KITITAS COUNTY

MEMORANDUM

TO: All Staff
FROM: Justin Turnbull, County Surveyor 
DATE: November 23, 2021
SUBJECT: County Survey Review of BL-21-00024 Curtis

CURTIS PROPERTY

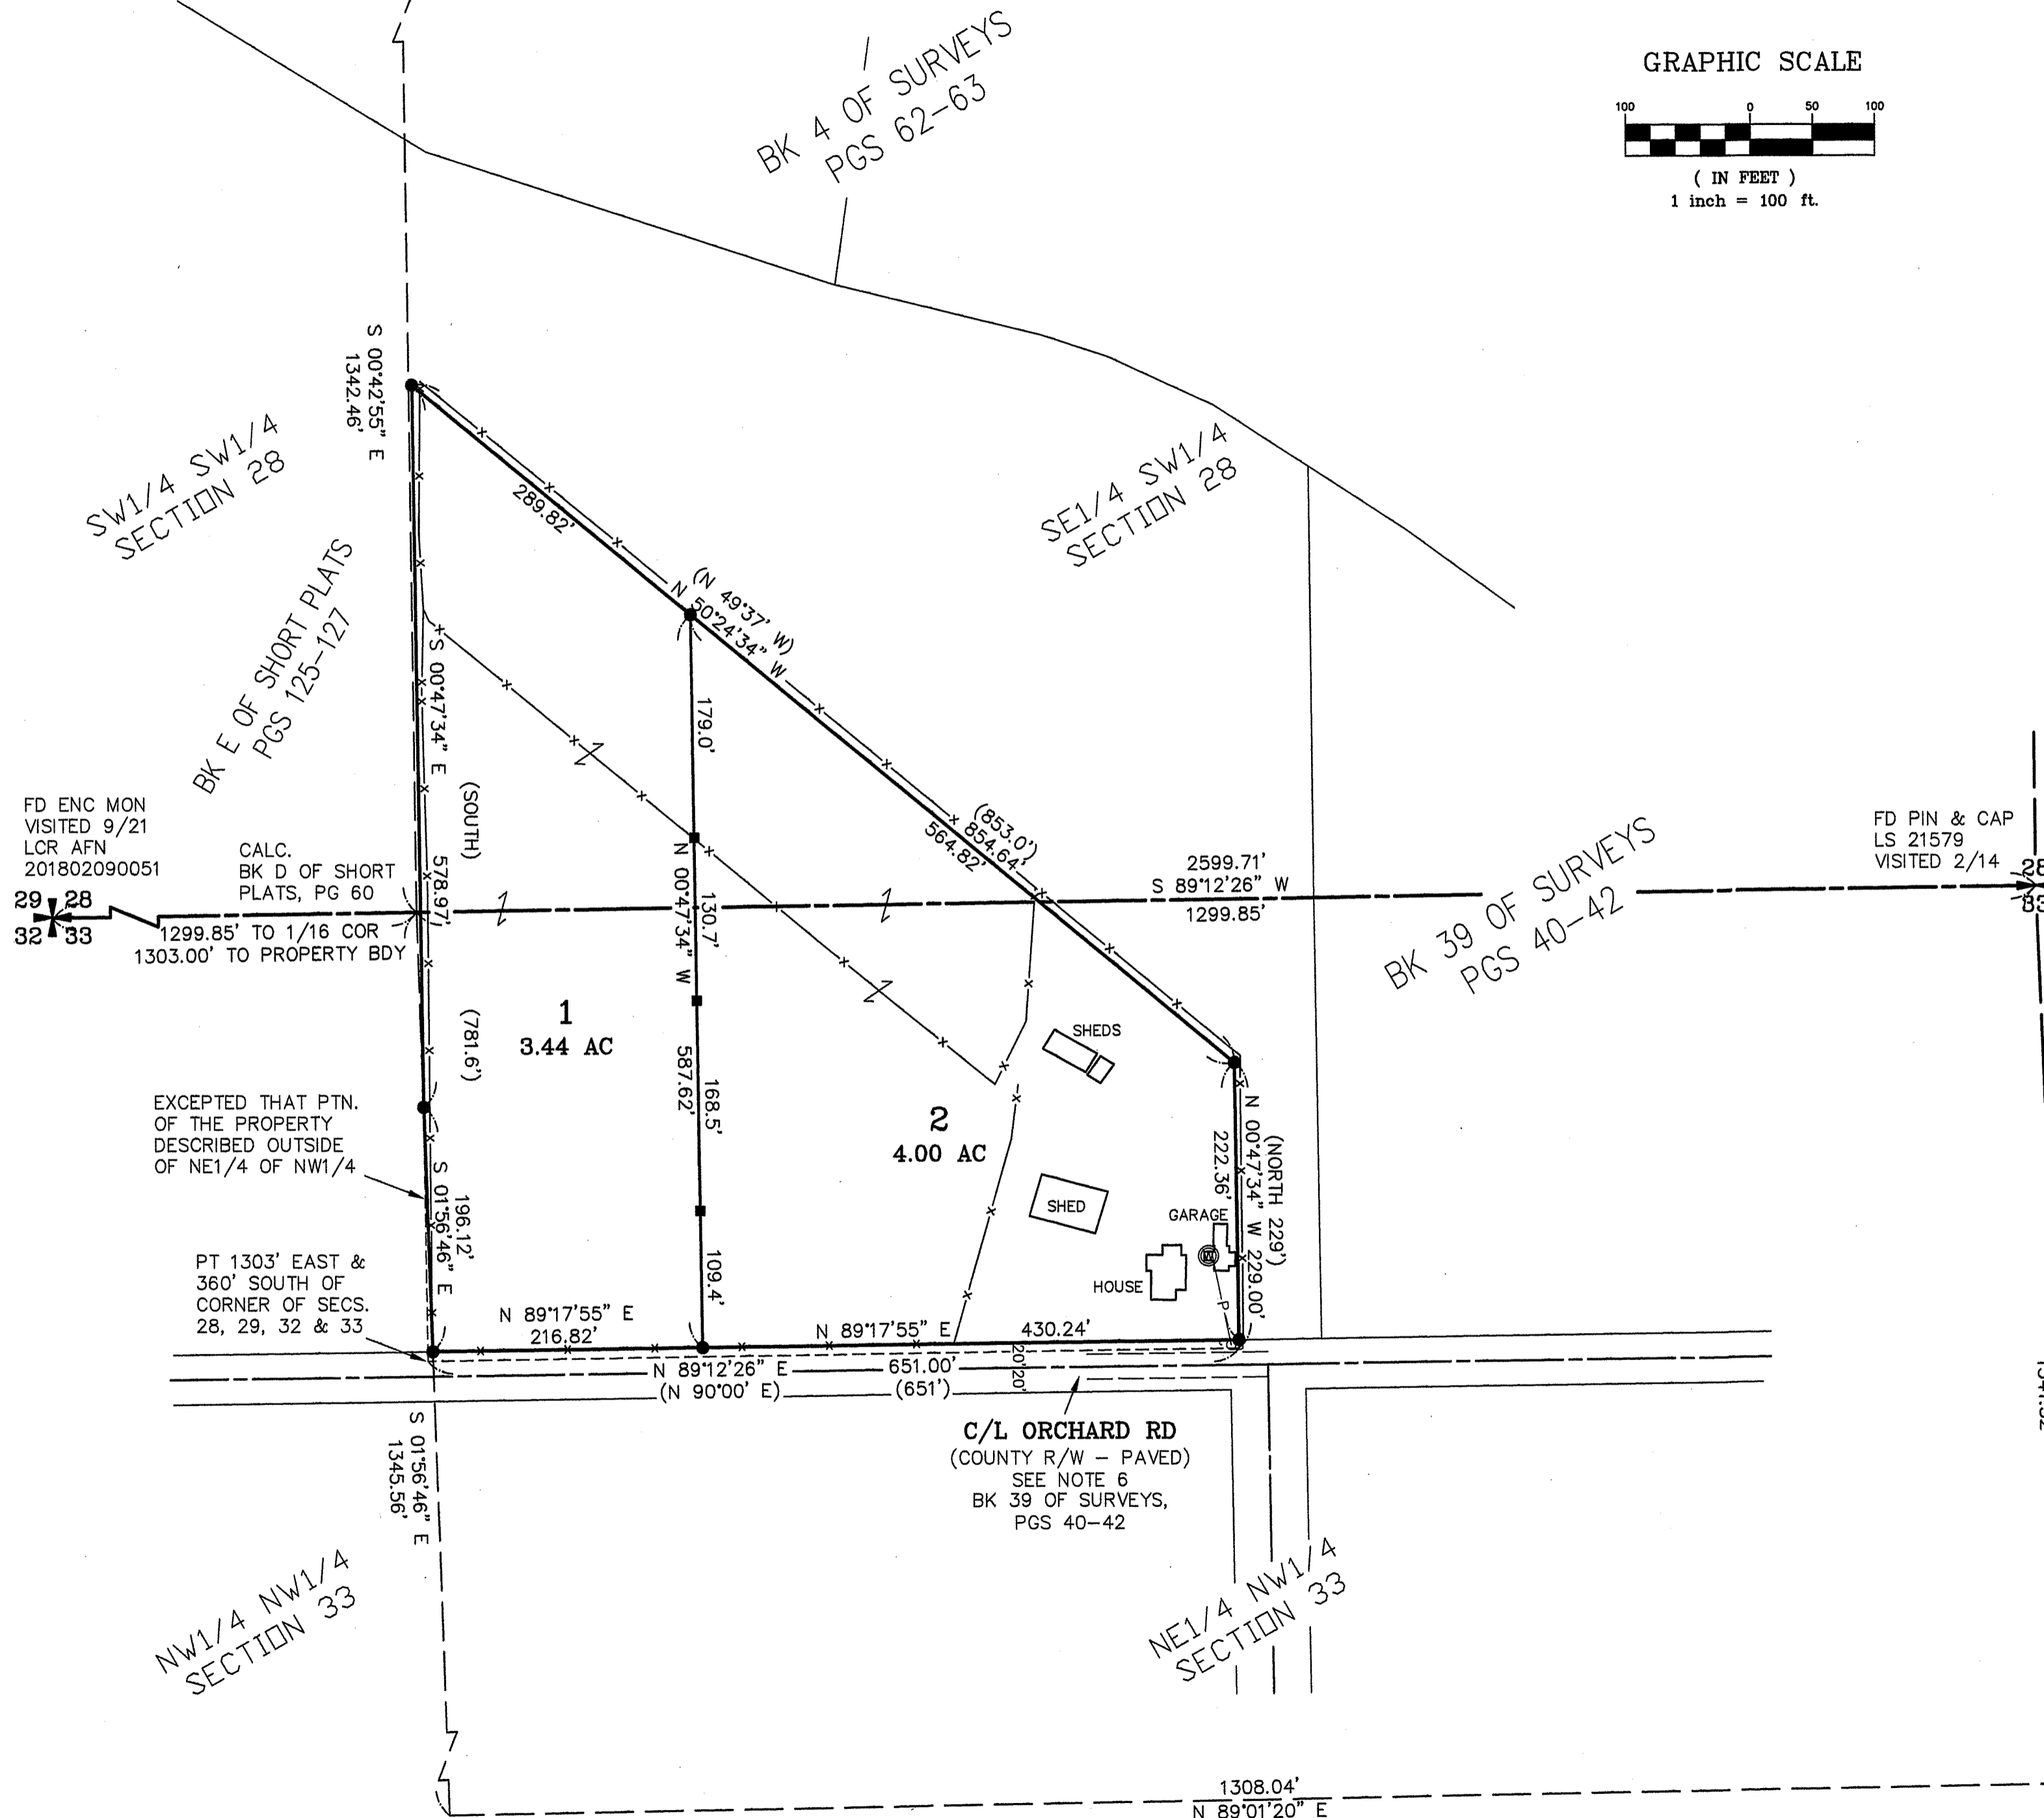
1. Please label existing and proposed boundaries to be revised by this BLA.
2. Please identify and dimension possible fence encroachments.
3. As the outside boundaries are not coincident with section lines, please show ties from section corners to parcel lines, suitable for retracement.
